25 February 2024

Planning application 22/00962

I need to make some changes to the planning application for Beachcombers and it is my understanding from Ms Amber Tonkin that I may do this using a s73 application. None of the changes are substantial so may be non-material amendments but Ms Tonkin said they could be done on a s73 form in any case. She also told me that this application is free if made within a year of the grant of the planning permission, which was 28 February 2023. I have enclosed a cheque for £234 but I am hoping that there is no charge as Ms Tonkin said.

**Drawing J1 - Front Elevation and Front part of  
 North Side Elevation**

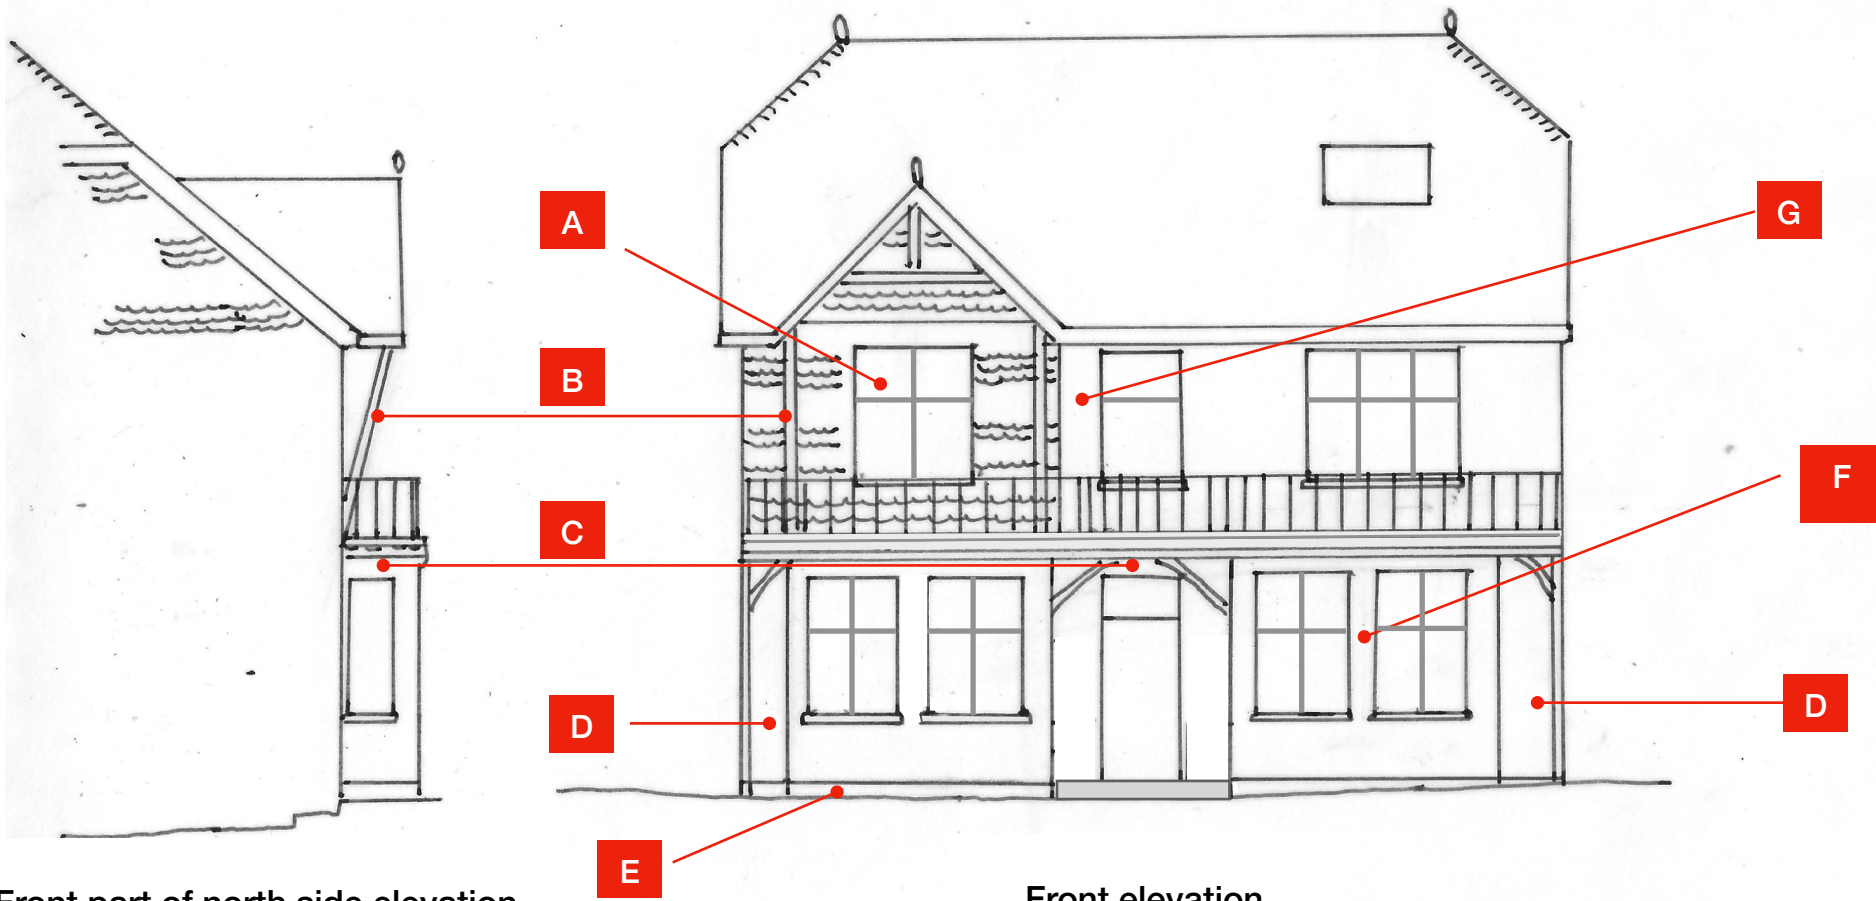
As I have said on the form, the work will now be done in stages to spread the cost. I have slightly changed the internal layout so that the house works from the outset. For example, I have moved the downstairs bathroom and reduced the size of the utility room which means I need to slightly change the doors and windows on the southern elevation and add another window (items H and I on drawing J2). The builder suggested I introduce a column into the middle of each front bay (item F on drawing J1) for ease of construction and I actually think it looks better and will be easier to fit with curtains or blinds, as the bay windows on the application were very large. As the builder has found out more about the structure of the house and the structural engineer has been involved, it is easier to use a large bracket (item B on drawing J1) to support the front bay overhang than posts due to the awkward alignment that the posts would have had with the bay below. To reduce cost at the moment I have scaled back the size of the porch to make a smaller porch (item C on drawing J1). We do not need as much tile hanging as the architect had shown on the drawings relating to the replacement of the bays on the front elevation - I can leave more of the existing render and brickwork as it is (items D and G on drawings J1). The builder and roofer have advised that a hipped roof will look much nicer for the rear dormers so I have made slight changes to incorporate that and bring the tops of the dormers into line and increase the slope of the middle dormer roof slightly to make tiling easier (items J and K on drawings J2 and J3). I have added a rendered skirt along the base of the front elevation (item E on drawing J1 and J2) to try to give an impression of a lower window sill. I have seen this on lots of Victorian and Edwardian houses and I think it looks very attractive. The internal floor level is quite a bit higher than the ground at the front of the house so I thought that the skirt would break up the relatively large area of brickwork below the bay windows.
